Welwyn & Hatfield Borough Council  
The Campus,  
Welwyn Garden City,  
Hertfordshire,  
AL8 6AE

Your ref: **6/2021/2125/MAJ**

**Re: Hertfordshire Constabulary Headquarters Redevelopment , Application for the Approval of Detail Reserved by Condition – Condition 7**

Drawing Status	
S3 - SUITABLE FOR REVIEW & COMMENT	
Project	Date DEC '22
HERTFORDSHIRE POLICE HQ DOG UNIT	Scale 1:500@A1
Drawn JT	Engineer AS
Title	Project No
HAUL ROAD GENERAL ARRANGEMENT & SETTING OUT	220802
Drawing No	Revision
HQDTC-CON-XX-XX-DR-C-03010	P01

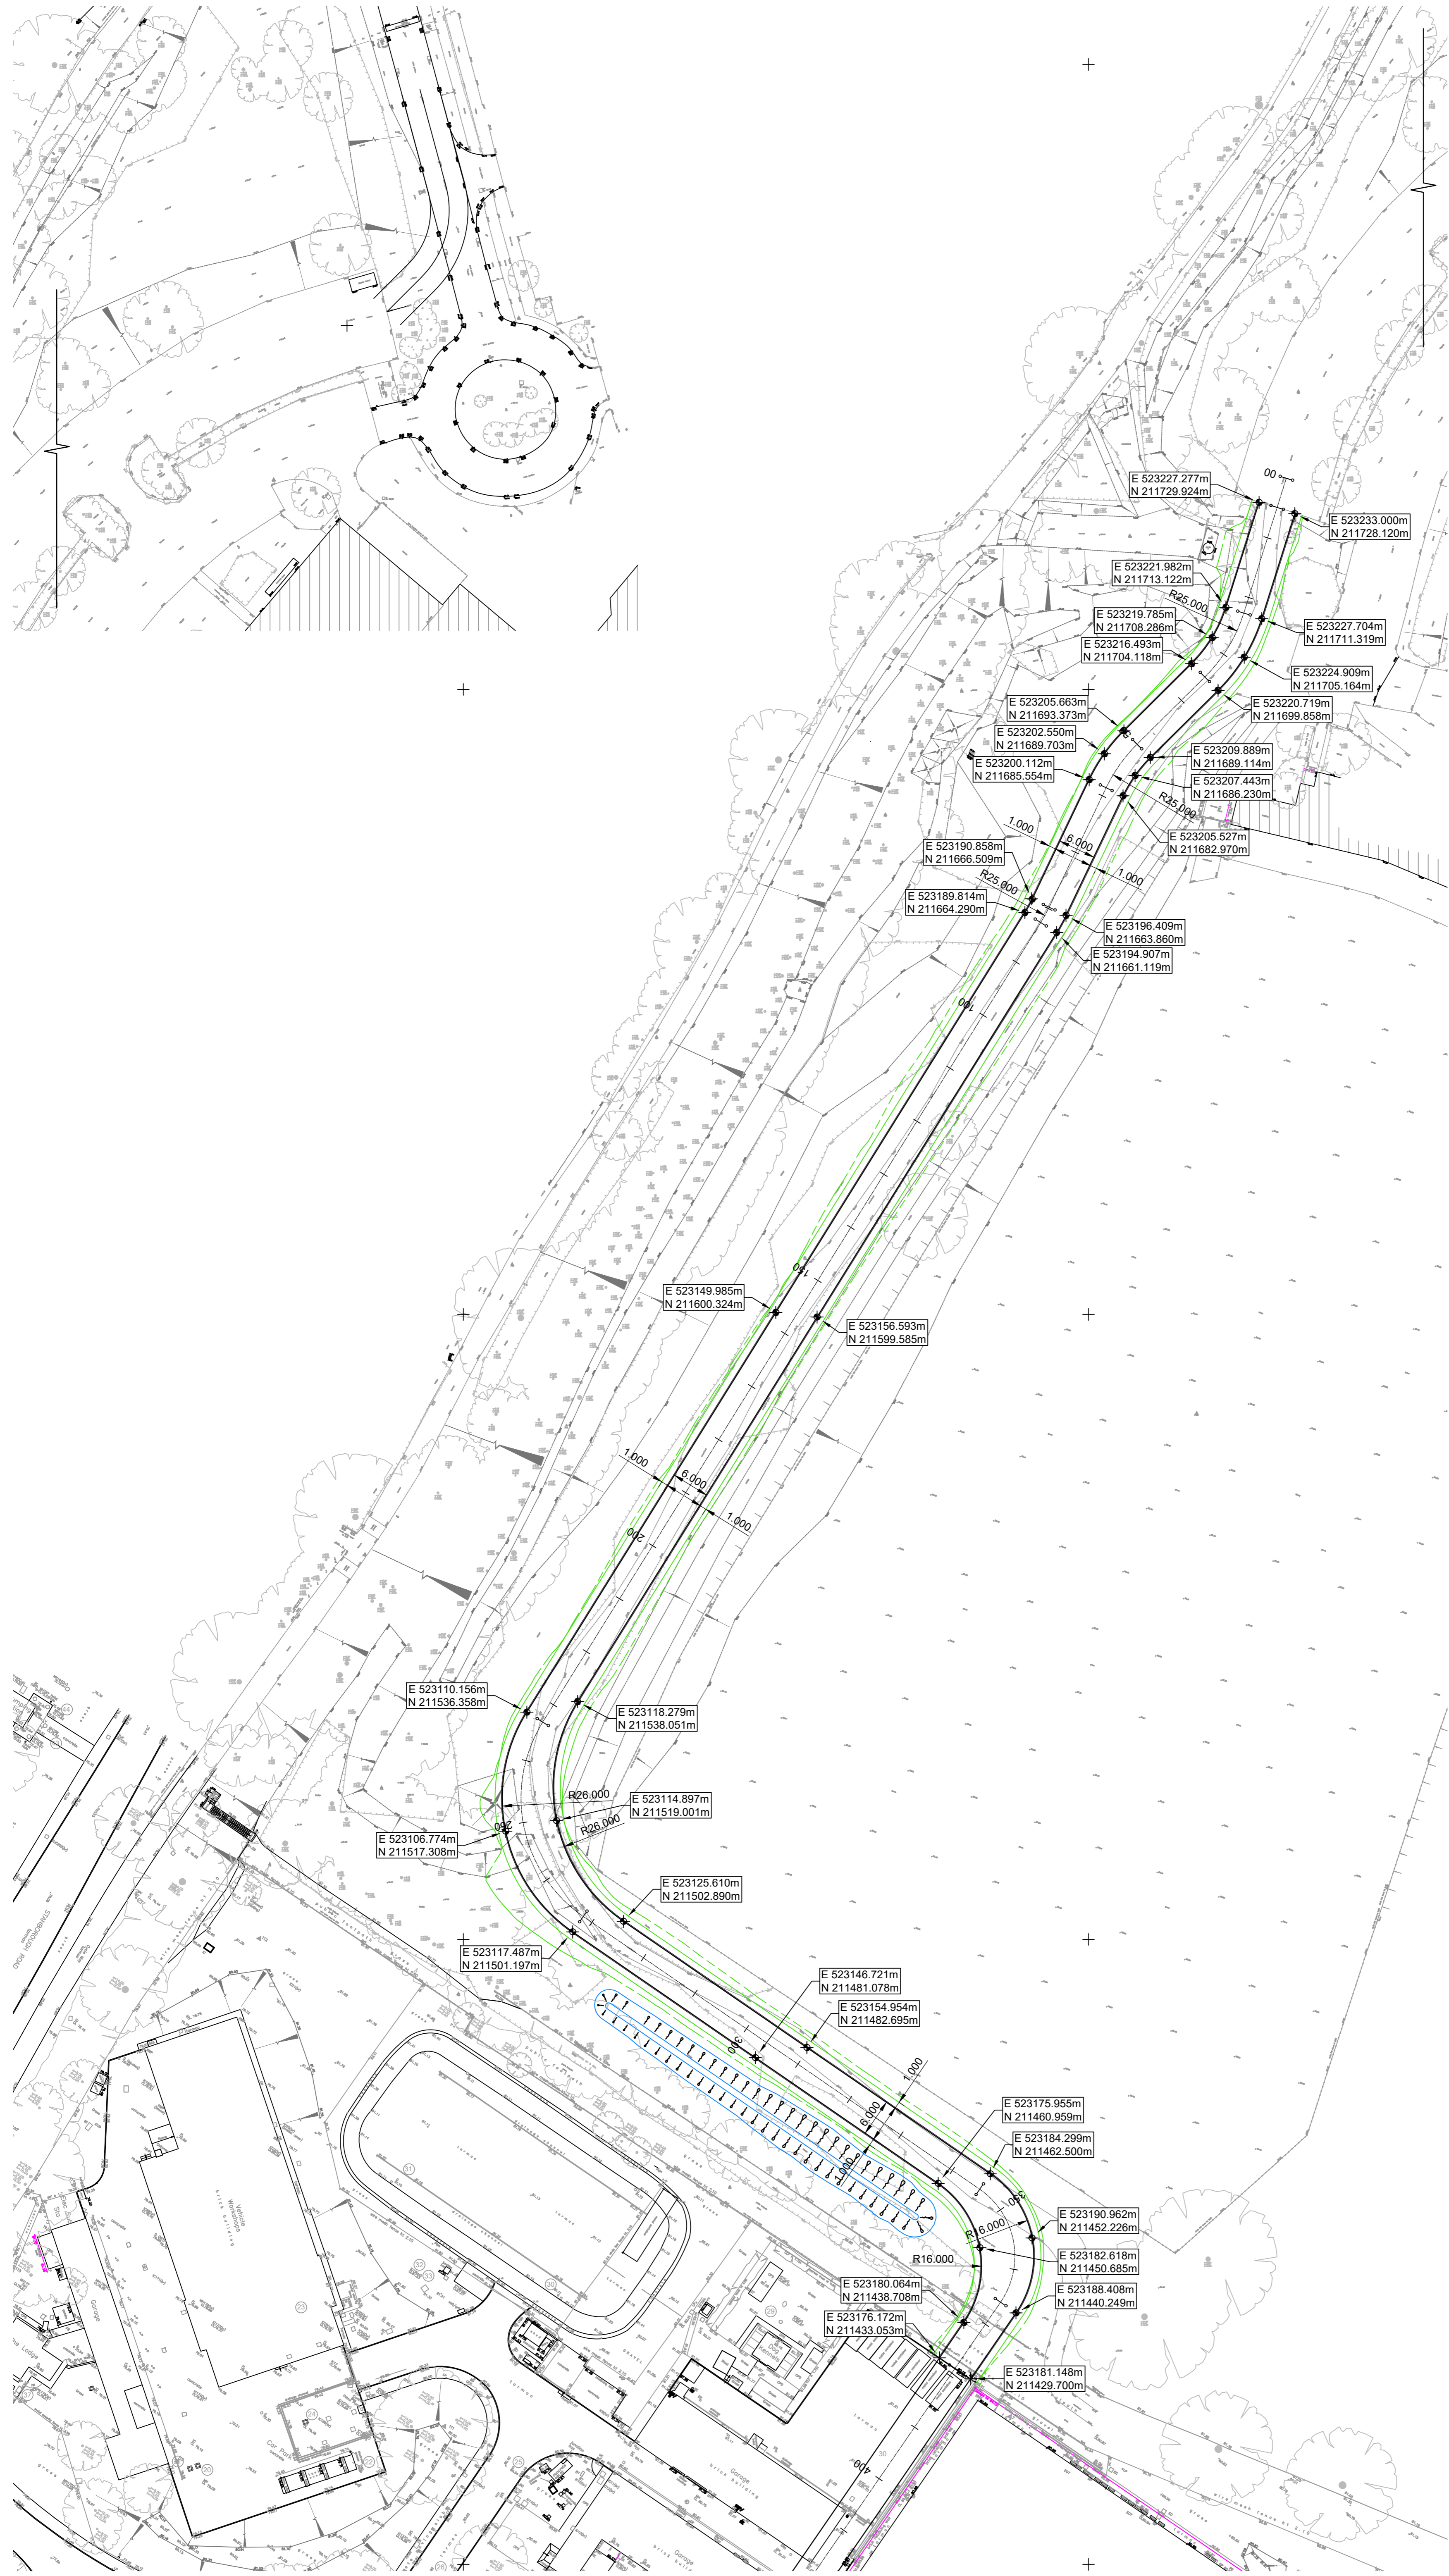
*No additional details have been provided of the final materials of the haul road and associated road. The 'Proposed Site Plan' also suggests that the hard surfacing would consist of compacted self-binding (hoggin) finish which is a standard material for haul roads. Notwithstanding this, taking into consideration the siting of trees and other vegetation along this route and the pressures of load bearing and root compaction from cars, lorries and other HGVs using the haul road on a frequent basis, it is advised that details of build-up information of the self-binding gravel should be provided for review. The details should demonstrate that the proposed haul road can accommodate the heaviest vehicles using the road and takes into account the frequency of equipment / traffic and HGV movements.*

Please find included within the re-submission the design build-up for the contractor's haul road.
